From: Gail Pilkington [REDACTED]
Sent: 05 June 2019 14:20
To: Amber Willard
Cc: Planning; Thanaluxmi Thirukkumar [REDACTED]
Subject: BR/107/19/PL 32 Argyle Road, Bognor Regis - Change of use to HMO
Attachments: Appeal decision LU11117PL 19 Bayford Road 6th June 2018.pdf; 32 Argyle Rd.As Exg Floor Plans.pdf; 32 Argyle Rd.As Exg Cross-Sections.pdf

Further to our telephone conversation last week I am emailing in response to the Bognor Regis Town Council objections published on the website regarding this application. Taking the points raised in turn:

DRAWING	NUMBER	201903.Exg 02
As Existing	REVISION	
Floor Plans	SCALE	1:100 @ A3
	DATE	March 2019

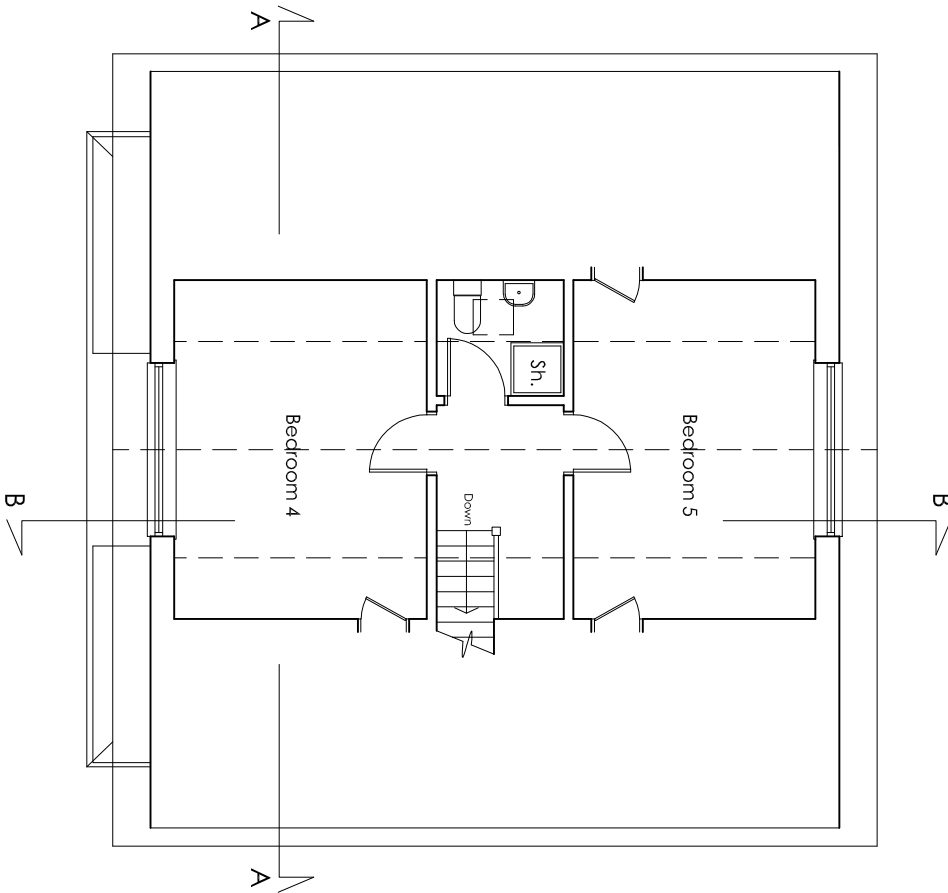
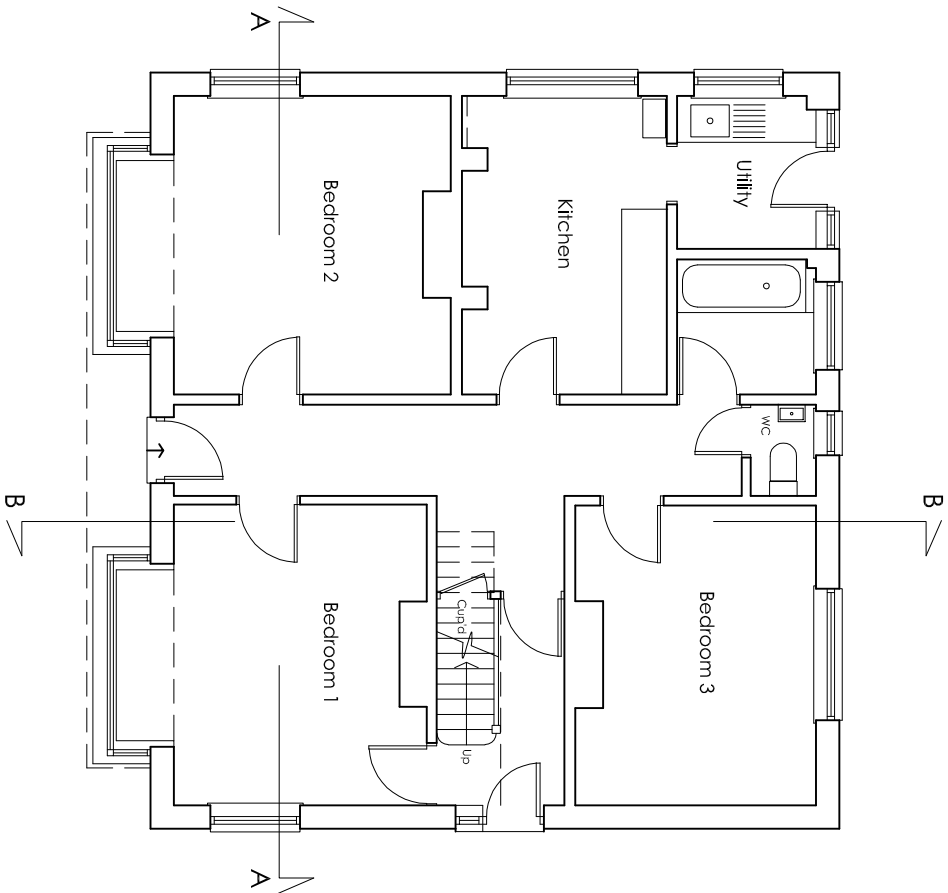
- 1) Concern is raised that this application would adversely affect the character of the area and tip the balance between different types of housing in that the HMO replaces a previous family home.

The HMO licence has now been received and this requires the number of bedrooms to be limited to 4 with the provision of a shared living space for use by all occupants. Therefore one of the ground floor rooms previously identified as bedroom 3 is now allocated as a sitting/dining room. The proposal therefore is now for a 4 bedroom 8 person HMO as shown on the attached substitute plans 201903.Exg 02, and 201903.Exg 04.

DRAWING	NUMBER
As Existing	201903.Exg 01
Block Plan / Location Plan	REVISION
PROJECT	SCALE
Change of Use, 32 Argyle Road	1:500 and 1:1250
West Sussex PO21 1EA	DATE
	March 2019

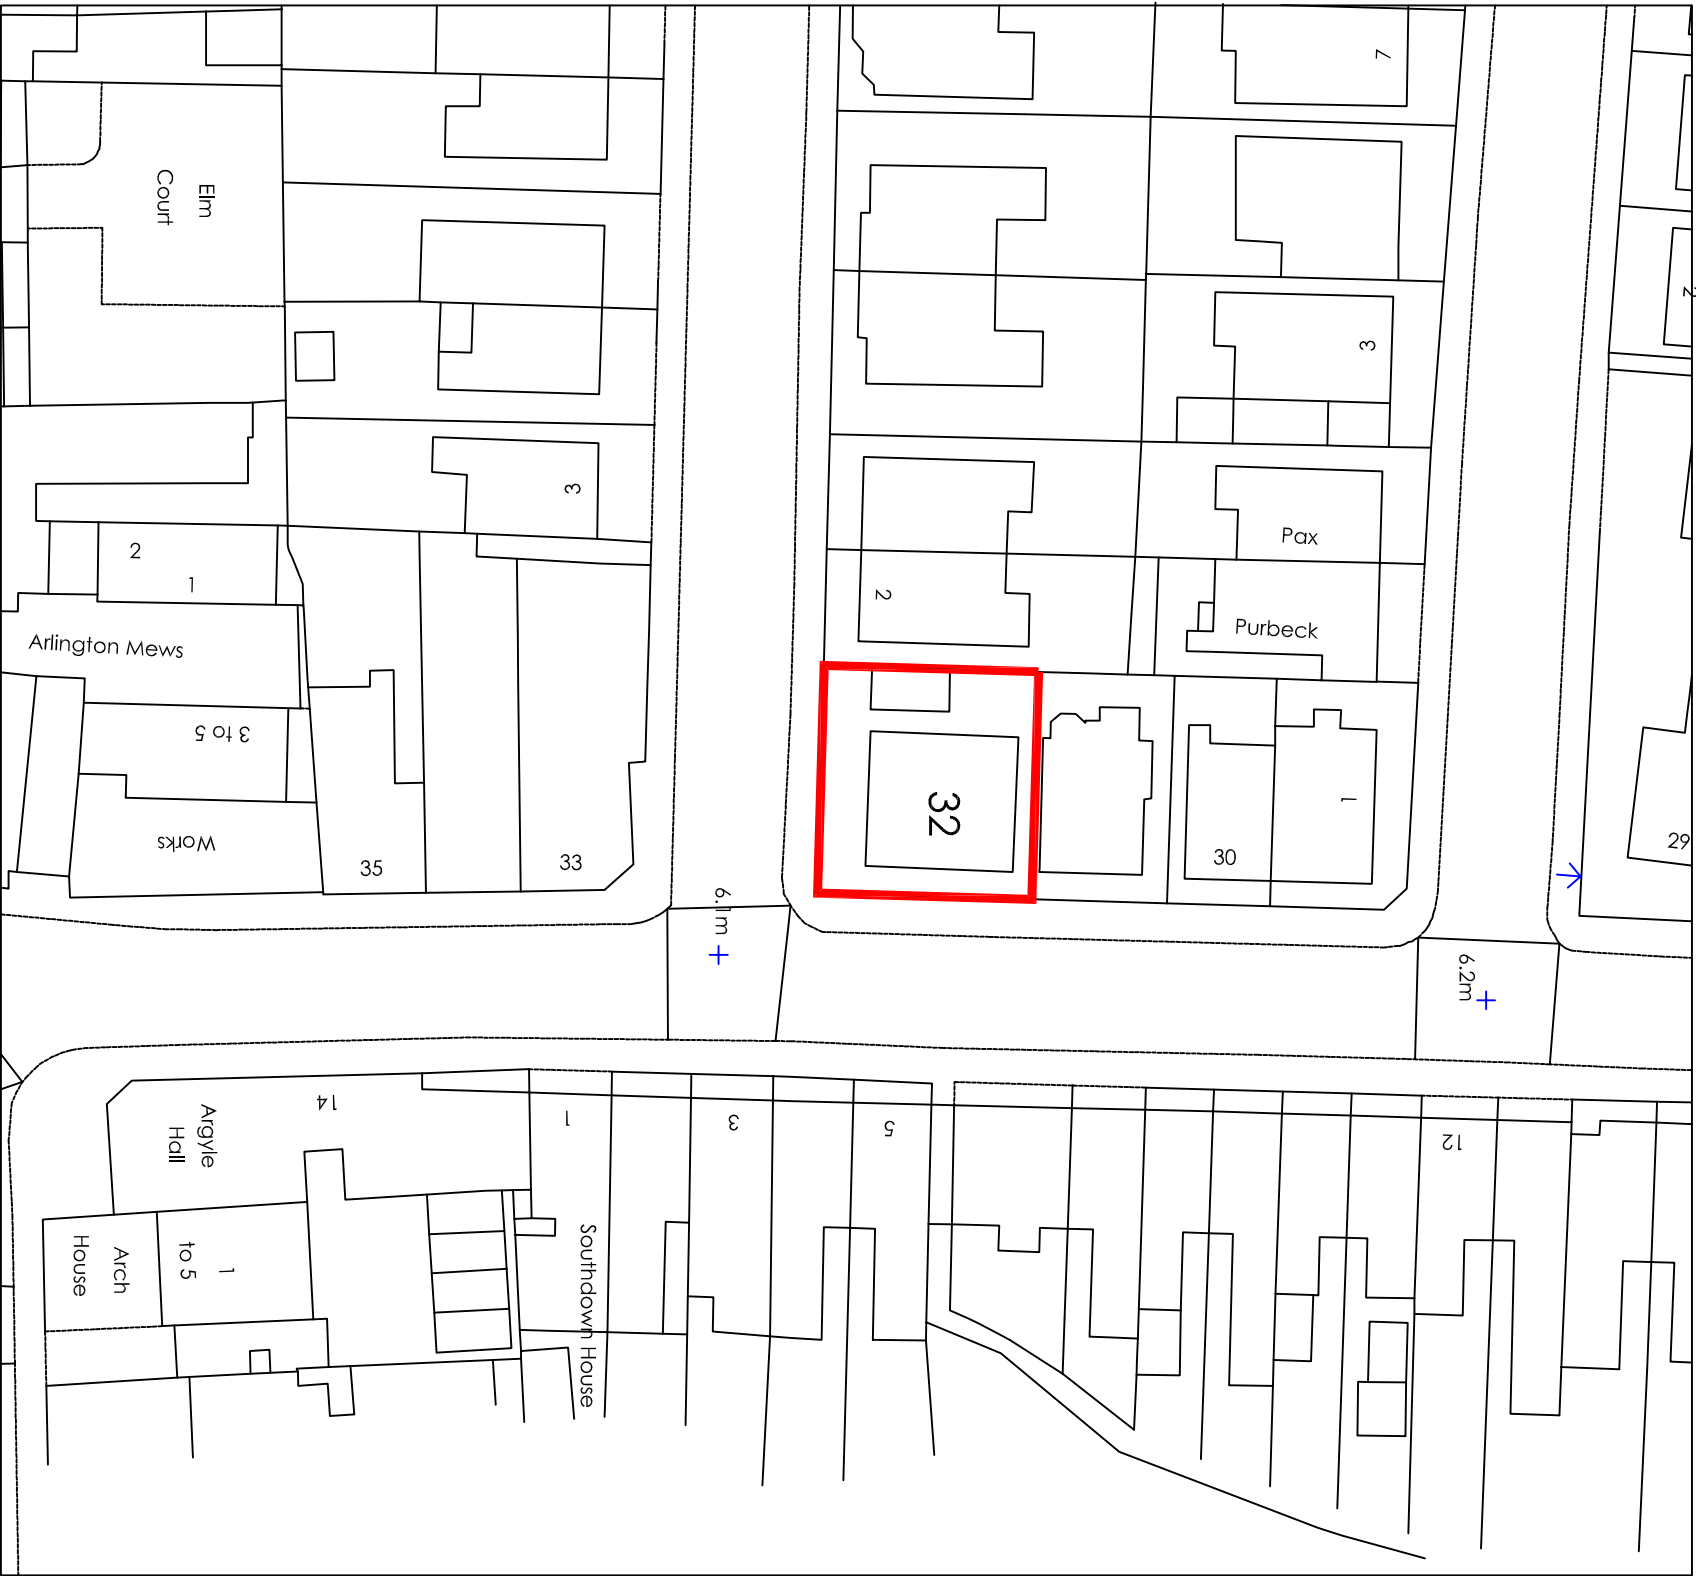
3) Concern that there is insufficient open space for 8 residents.

Response: With regards to policy H SP4(c) of Arun Local Plan, this requires that proposals provide adequate areas of open space. However whilst there are no plan policies covering external amenity space or gardens, the proposal benefits from a small outside area (around 4m by 3m) where residents are able to sit outside. This type of open space is less suitable for a family garden and the amount of open space available is not dissimilar to that enjoyed by the immediately adjoining properties in Argyle Road to the north. This can be confirmed from the block plan submitted with the application.
